City of Portland, Maine - Building or Use Permit Application 389 Congress Street, 04101, Tel: (207) 874-8703, FAX: 874-8716

Location of Construction: 21 Buca Run <i>Lot 16</i>		Owner: Custom built Homes of Maine		Phone: 892-3149		Permit No: 990224	
Owner Address: 27 Main St Windham ME		Lessee/Buyer's Name:		Phone:		BusinessName:	
Contractor Name: Custom Built homes of Maine		Address: 27 Main St Windham ME		Phone: 892-3149		Permit Fee:	
Past Use: Vacant		Proposed Use: 1-fam		COST OF WORK: \$ 70,000		PERMIT FEE: \$ 370.00	
Proposed Project Description: Construct Single Family Dwelling		FIRE DEPT. <input type="checkbox"/> Approved <input type="checkbox"/> Denied		INSPECTION: Use Group: <i>R3</i> Type: <i>5B</i> <i>BOCA96</i>		Signature: <i>[Signature]</i>	
		Signature:		Signature: <i>[Signature]</i>		Zone: <i>R-2</i> CBL: <i>336-A-06</i>	
		PEDESTRIAN ACTIVITIES DISTRICT (P.A.D.)		Action: <input type="checkbox"/> Approved <input type="checkbox"/> Approved with Conditions <input type="checkbox"/> Denied		Signature: _____ Date: _____

RE: Certificate of Occupancy
21 Buca Run (Lot 16)

**CITY OF PORTLAND, ME
BOCA 1996 Plan Review Record
One and Two Family Dwelling**

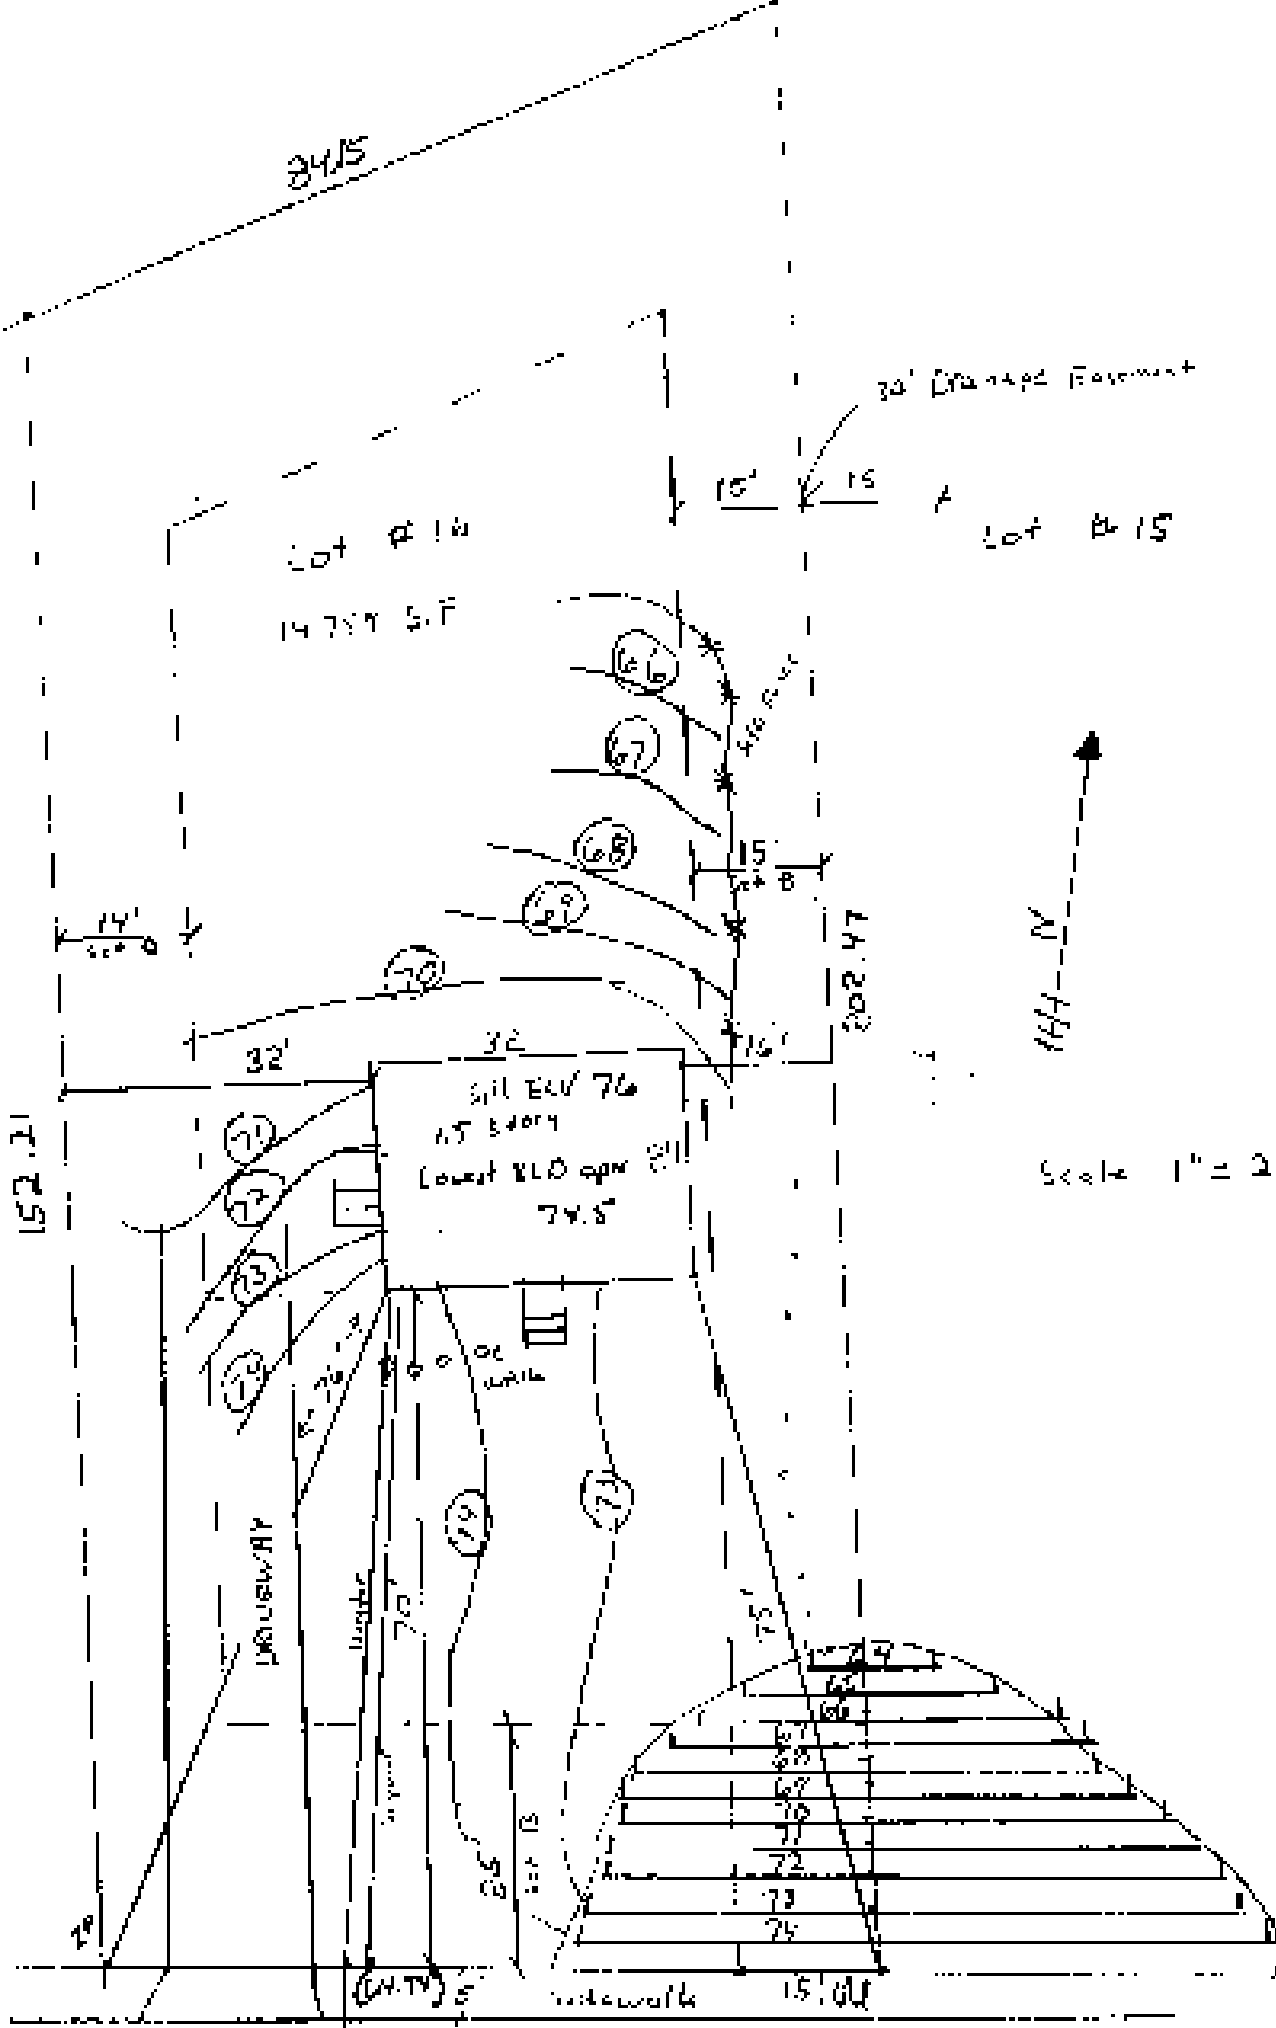
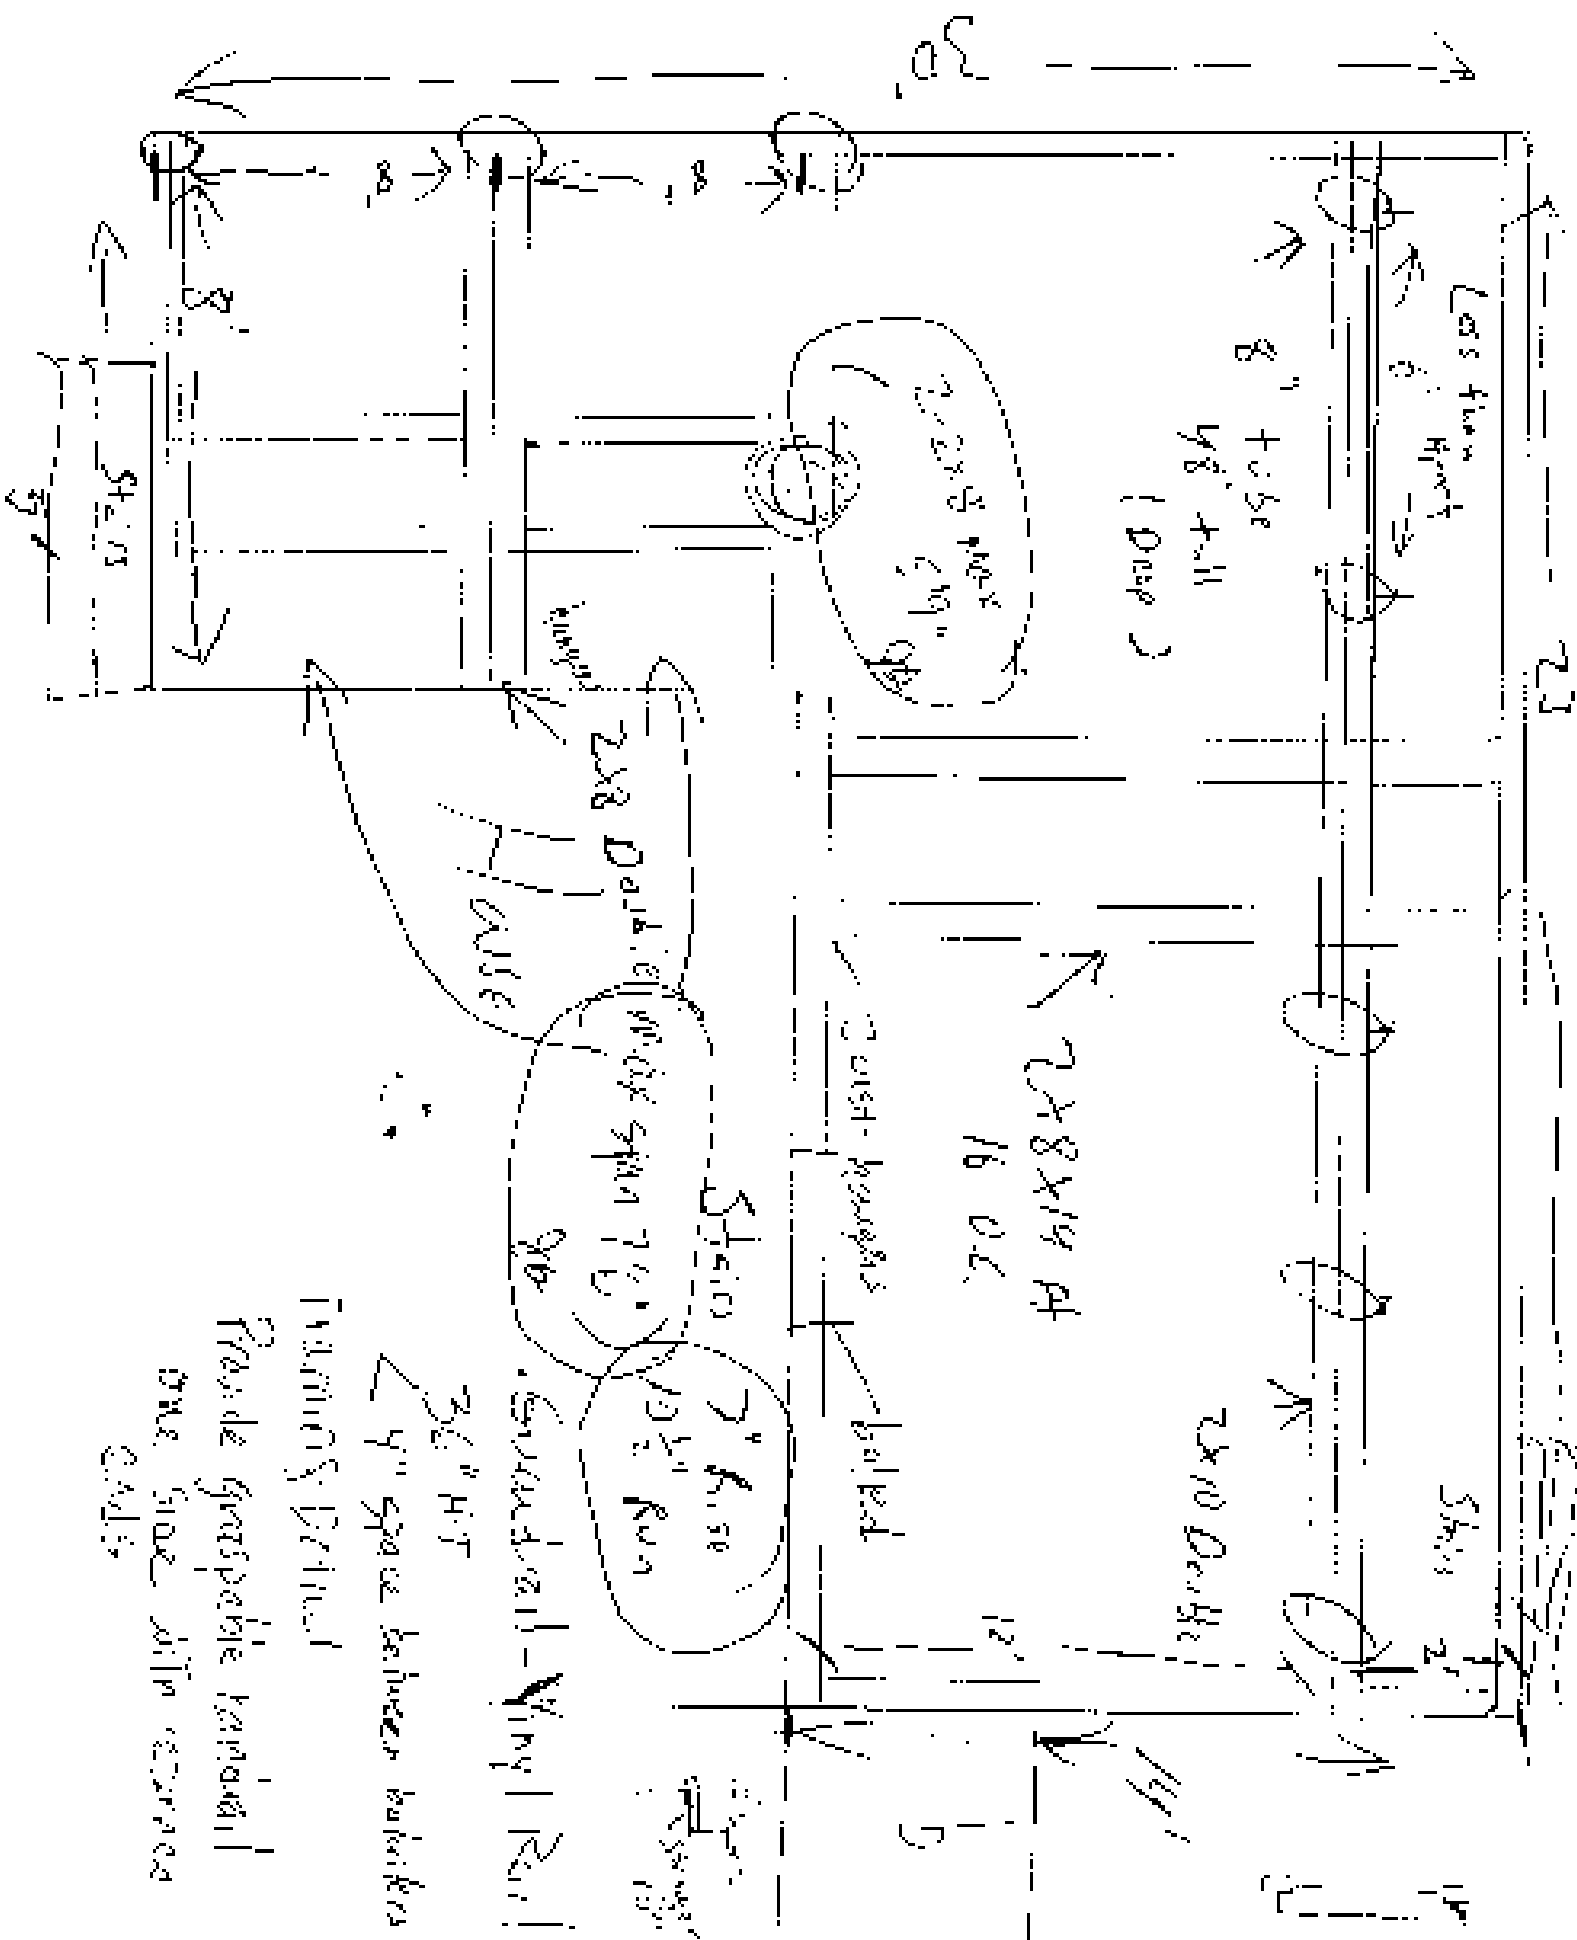
1. There are no City approved species of trees planted on the lot frontage. This work must be completed by June 3, 1999.
2. The site has been loamed, but no growth of grass has occurred. This work must be completed by June 3, 1999.
3. The sidewalk that crosses the driveway has been damaged, and needs to be repaired. This work must be completed by June 3, 1999.
4. A riprapped drainage channel should be constructed from the rooflines towards the swale area to convey runoff. Alternatively, the lot could be regraded to channel the runoff elsewhere. This work must be completed by June 3, 1999.
